Your reference: SSD 7942

**RE: URBNSURF Sydney, Pod B P5 Carpark, Hill Road, Sydney Olympic Park**

The Environmental Impact Statement (EIS) for the above State Significant Development (SSD) was referred to Sydney Olympic Park Authority (the Authority) for comment on 7 July 2017. The Authority has reviewed the submitted application and provides the following comments, supported by recommended conditions of consent at Appendix A.

| Title: 50lux min MH=25m | Designer: AP | Date: 3/9/2017 |

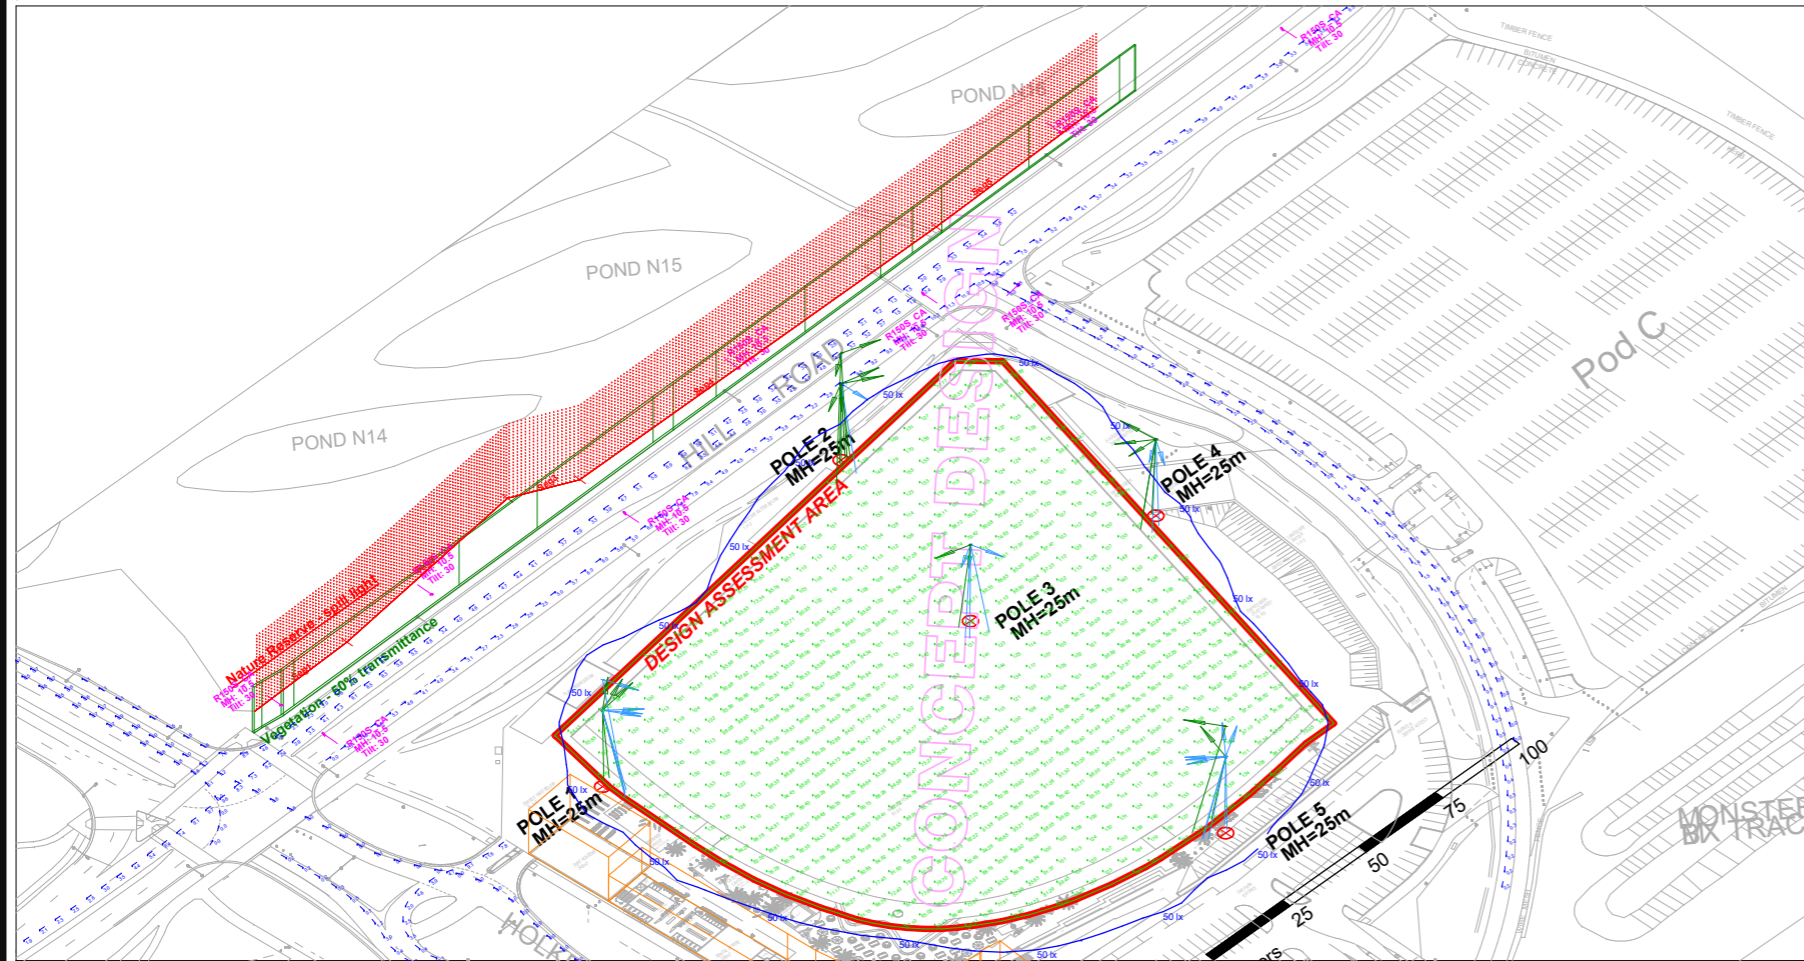
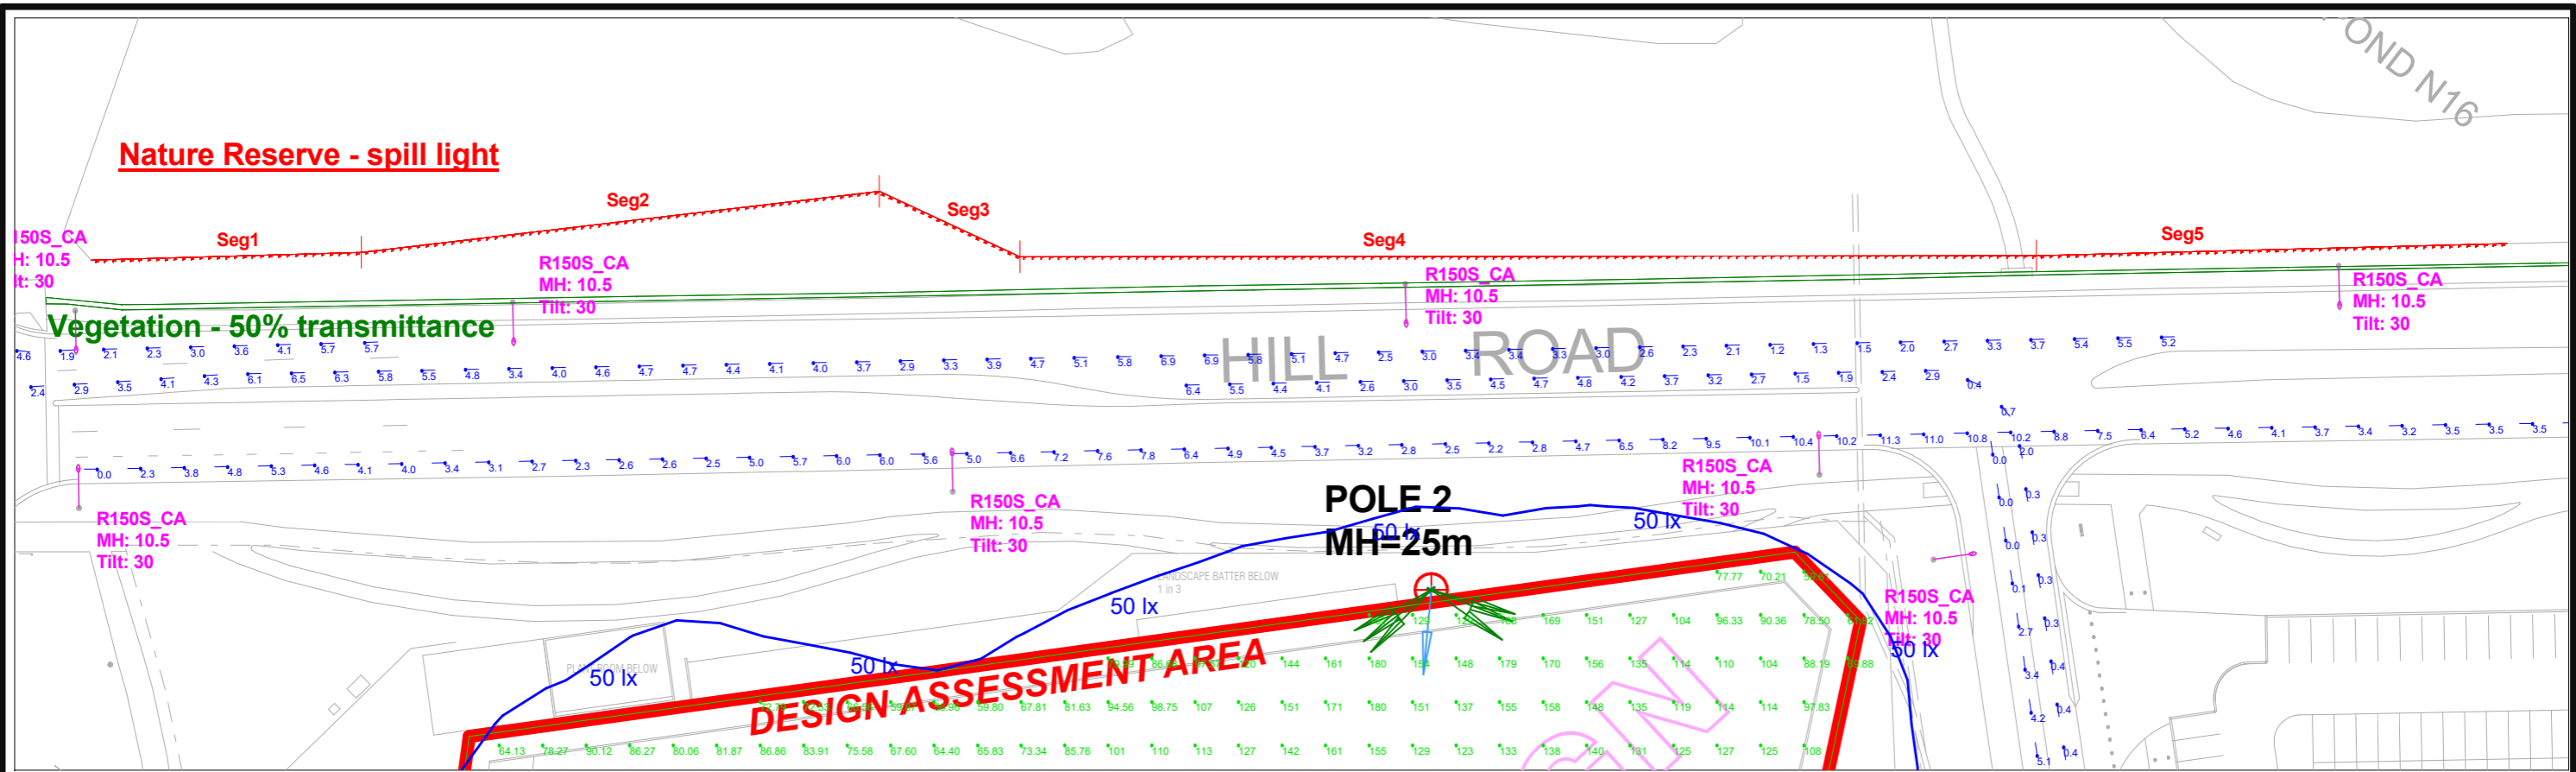
It is noted that sports lighting poles are proposed to be installed around the lagoon. Given the close proximity to endangered fauna species, the Authority supports the recommendations of the Applied Ecology (24 February 2017) fauna report with regard to directing all lighting downward and using energy efficient lamps and by ensuring that all outdoor security and display lighting is fitted with quality shielded flood lights and energy efficient lamps which are directed at the target area only.

The Authority has provided additional recommended conditions with regard to lighting as it should be noted that Australian Standard AS 4282: 1997 Control of the Obtrusive Effects of Outdoor Lighting does not address ecological impacts of artificial night lighting, it is concerned only with human impacts. The Authority considers it is not sufficient to require the applicant to only comply with this standard.

1. All lighting shall be designed and operated in a manner that excludes upwards-pointing lights, and minimises lightspill to Narawang Wetland and Haslams Creek habitats.
2. The luminaire design of the sports lighting poles shall include cut-off fixtures such that all light is directed downwards to the target area. Tall sports lights shall only be operated during the approved facility operating hours.
3. Outdoor security and display lighting shall be fitted with cut-off fixtures such that light is directed at the target area only.
4. Sign lighting shall be directed downwards at the target area only.
5. Upwards-pointing searchlights (eg as event markers) shall not be used.
